LETTER OF INTENT

Request for Dimensional Variance – Existing Accessory Structures

PCD File No.: BOA261

Subject: Request for Dimensional Variance for Existing Accessory Structures

Title, "SITE PLAN"

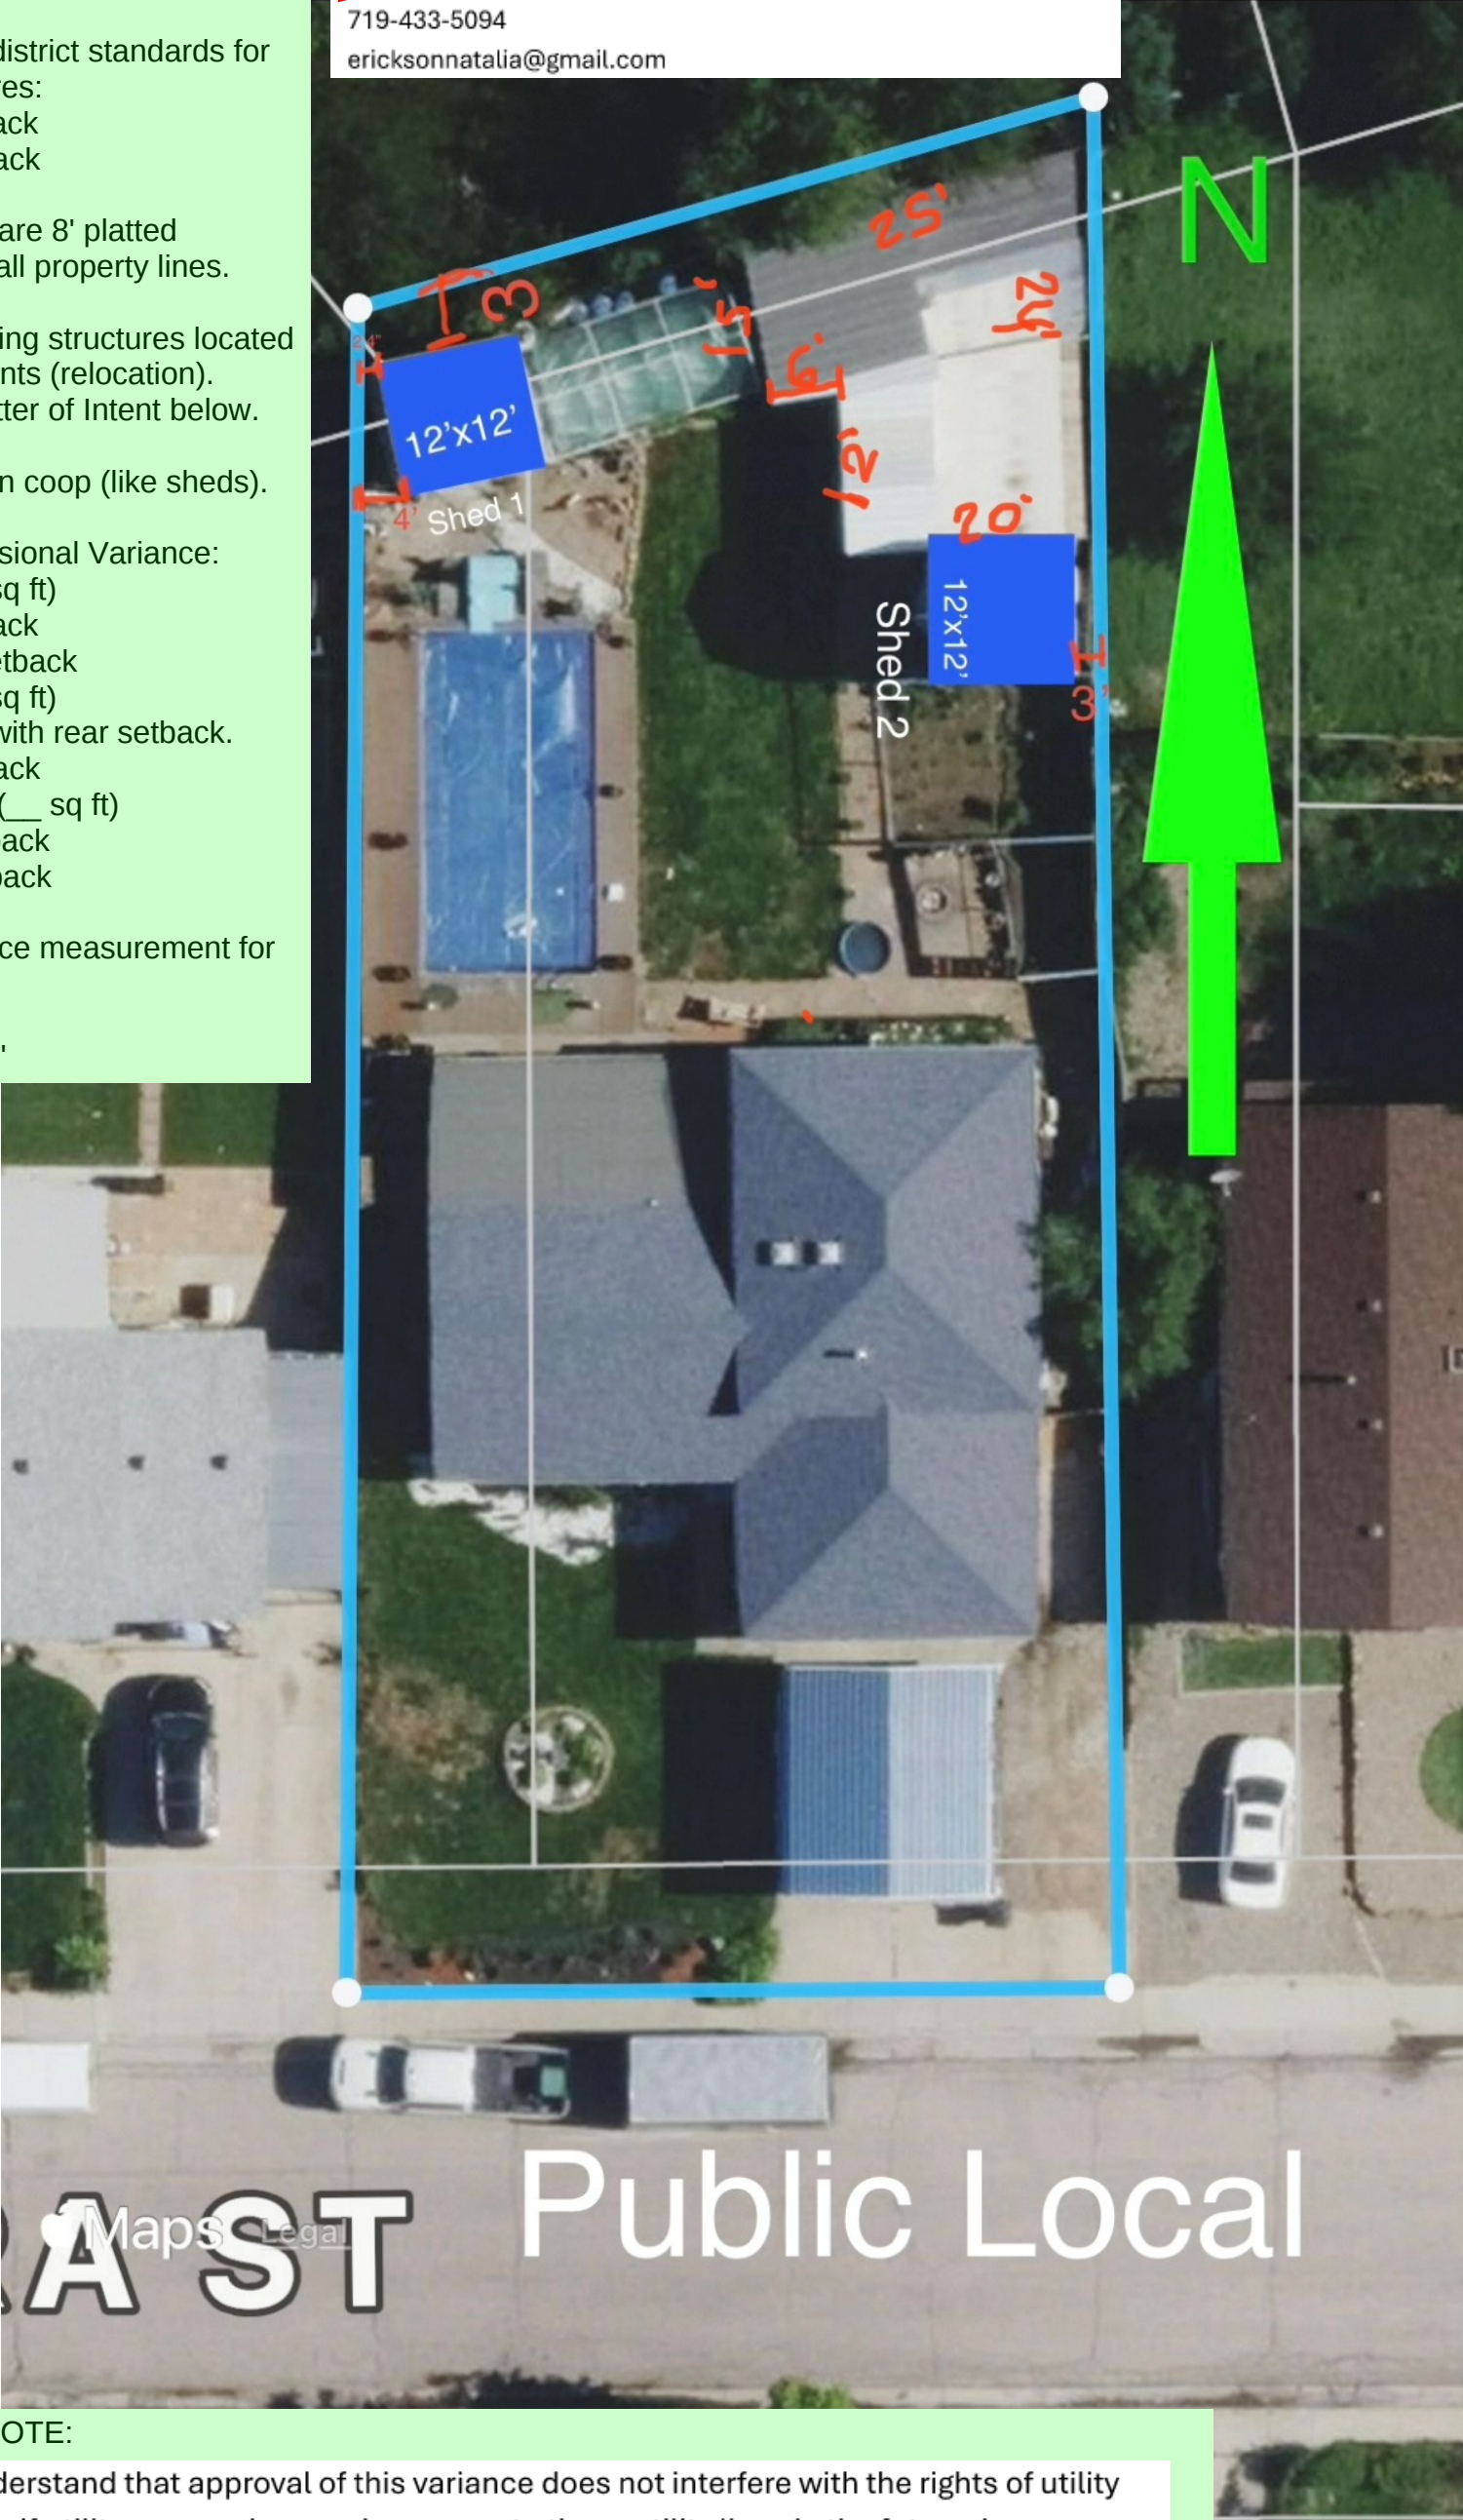
Please verify that this is the dimensional area for just the structure (building).

This description does not align with the pictures you provided.

The Pikes Peak Regional Building Department stated that there is a recorded non-compliance for structures- over 200 sq ft built without proper permits. A condition of approval with this dimensional variance request will be to obtain the appropriate permits with PPRBD. Please contact the building department for clarification, if needed.
